Our Ref: PEF/SD/28854
Your Ref: Y/21/18/DOC

30 April 2018

**Drainage
Land at Kings Close, Yapton**

JOB NO.	DRAWING NO.	REVISION
28854	106	P2

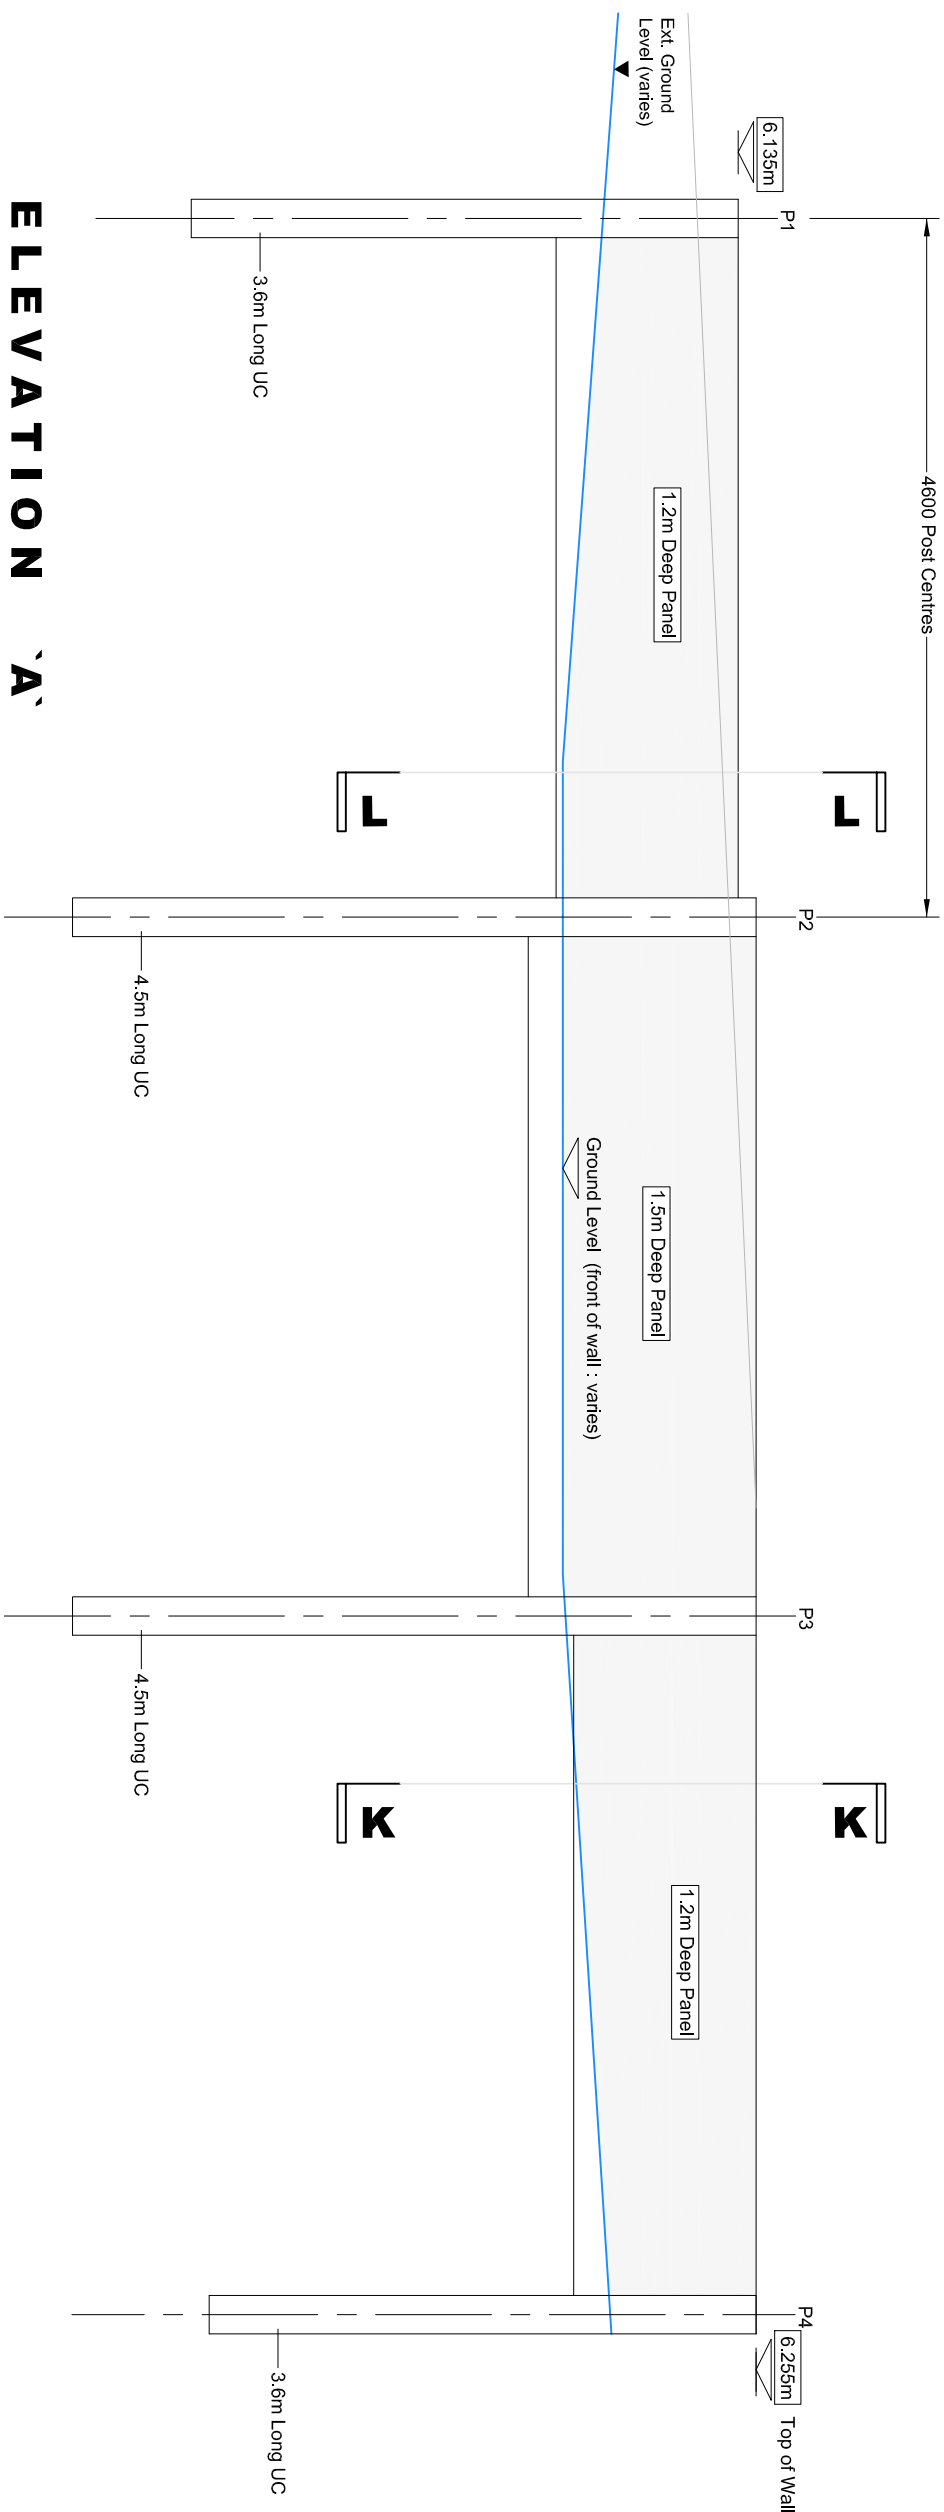
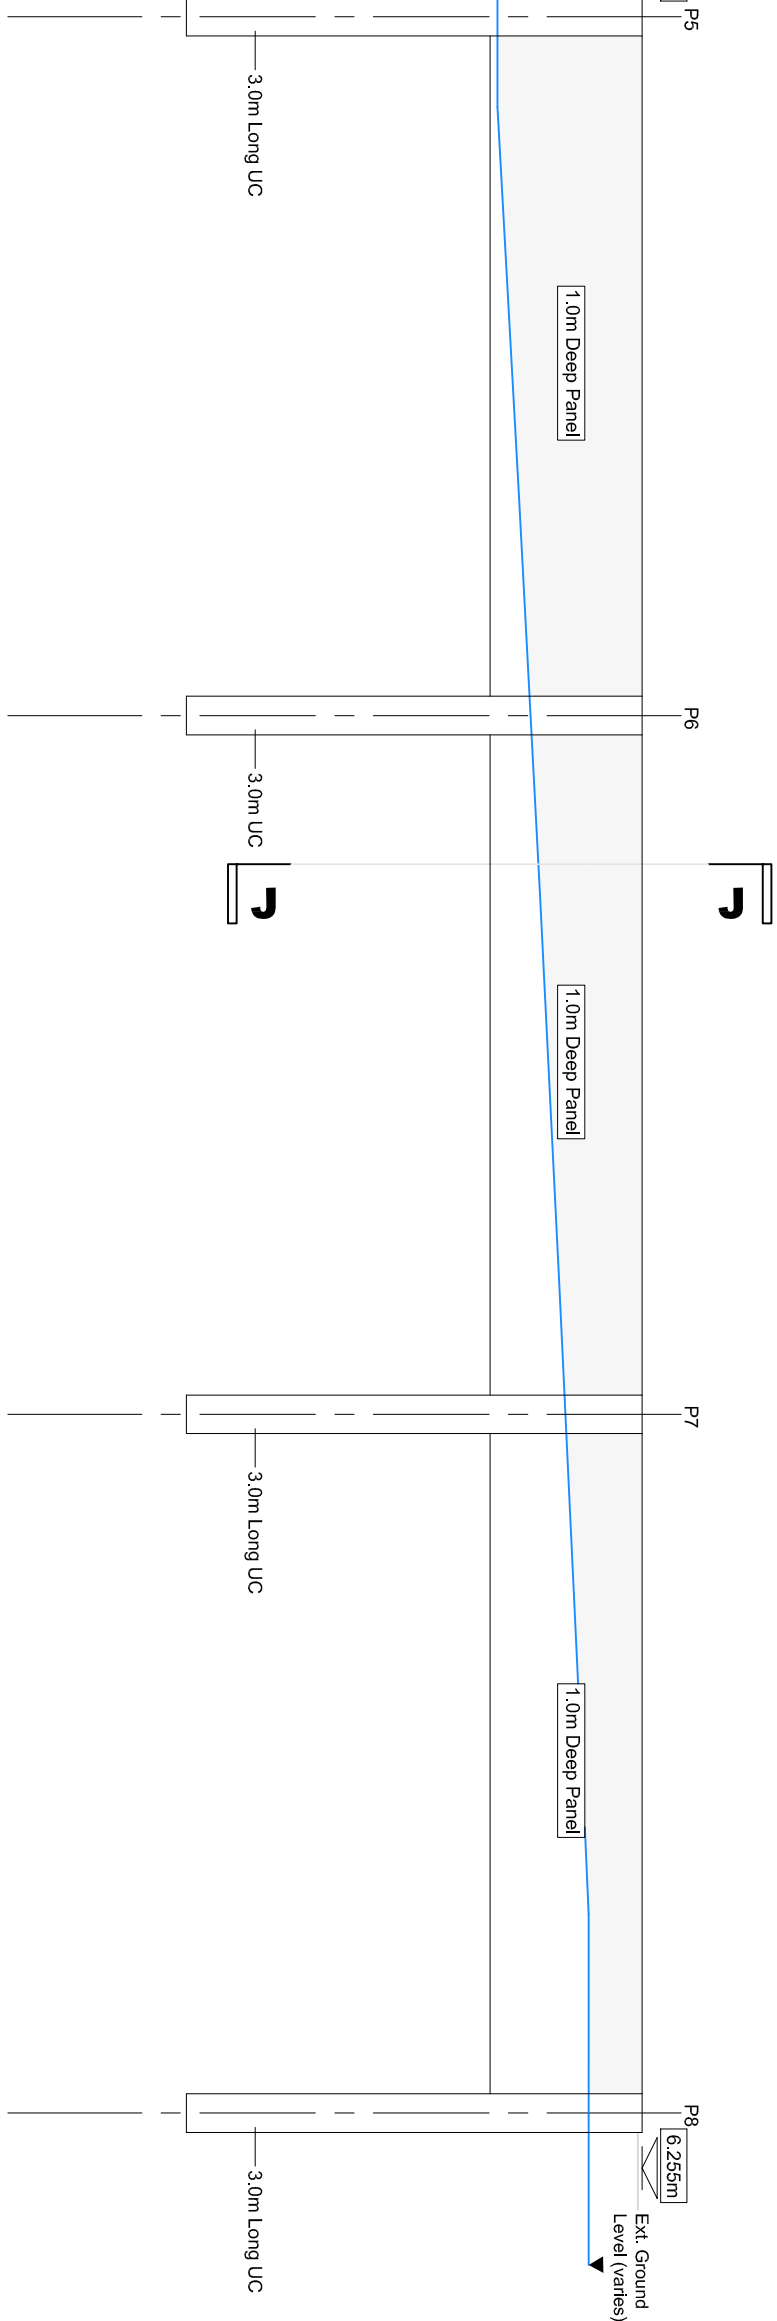
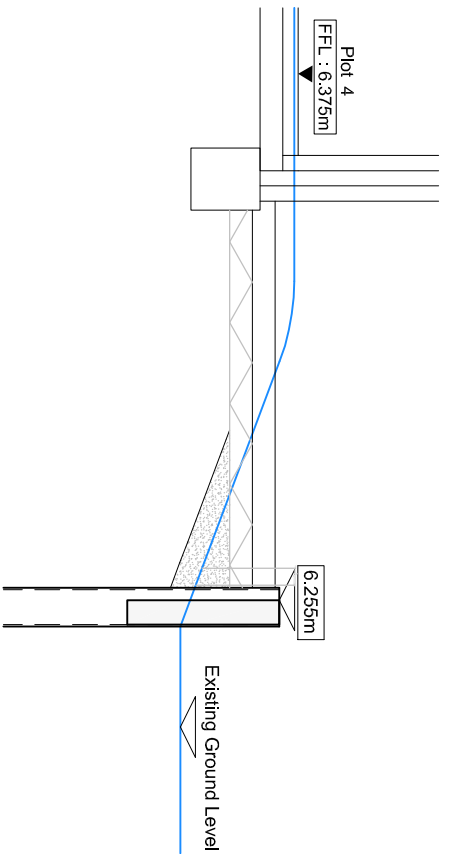
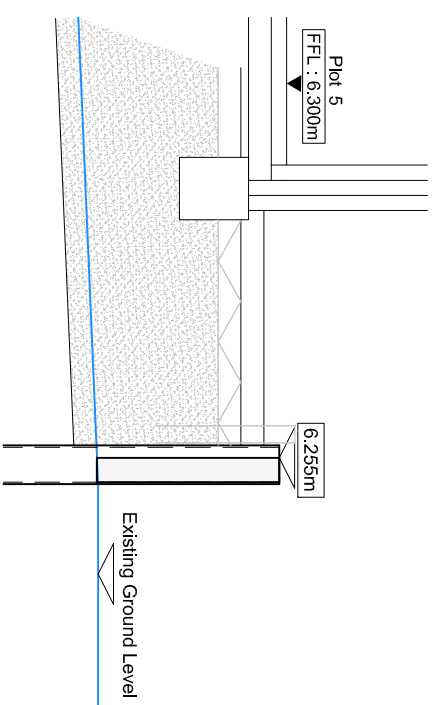
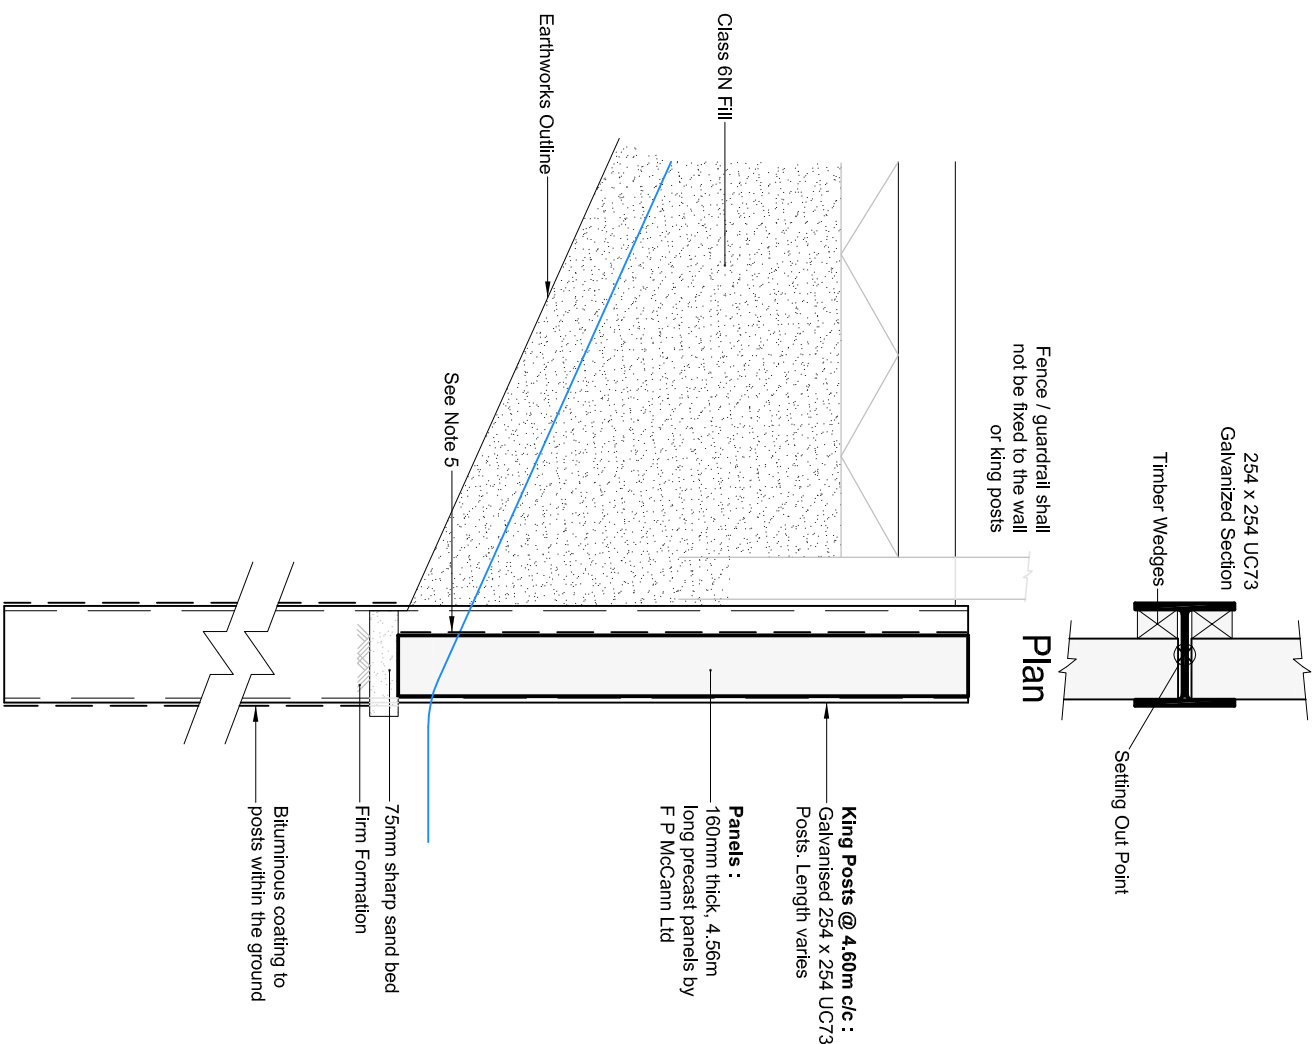
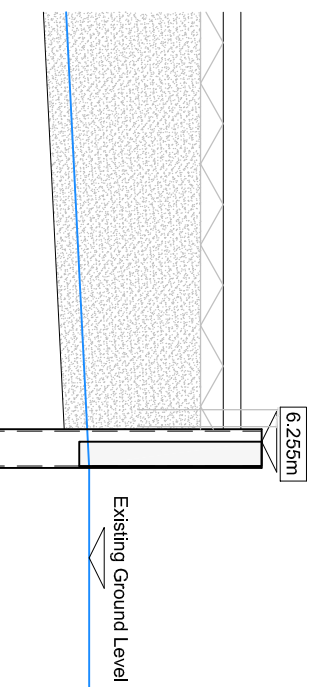
- Soakaway base and cover levels have been added to our drawing No. 28854-101.P4. Base levels represent the invert level of the storage void former.
- Step rungs have been added to our drawing No. STD.01.47A. Manholes Type P2 have not had step rungs detailed to accord with adopted manhole details.
- The depth of the concrete bed at the base of the catchpits has been increased to 225mm.
- Manhole cover types and grades are shown on the schedules and standard drawings. Cover grades A15, B125, C250 and D400 imply compliance with BS EN124.
- Our marked-up drawing shows flood exceedance flow routes.
- Drawings 106.P2 and 107.P1 show sections through the proposed king post retaining wall.
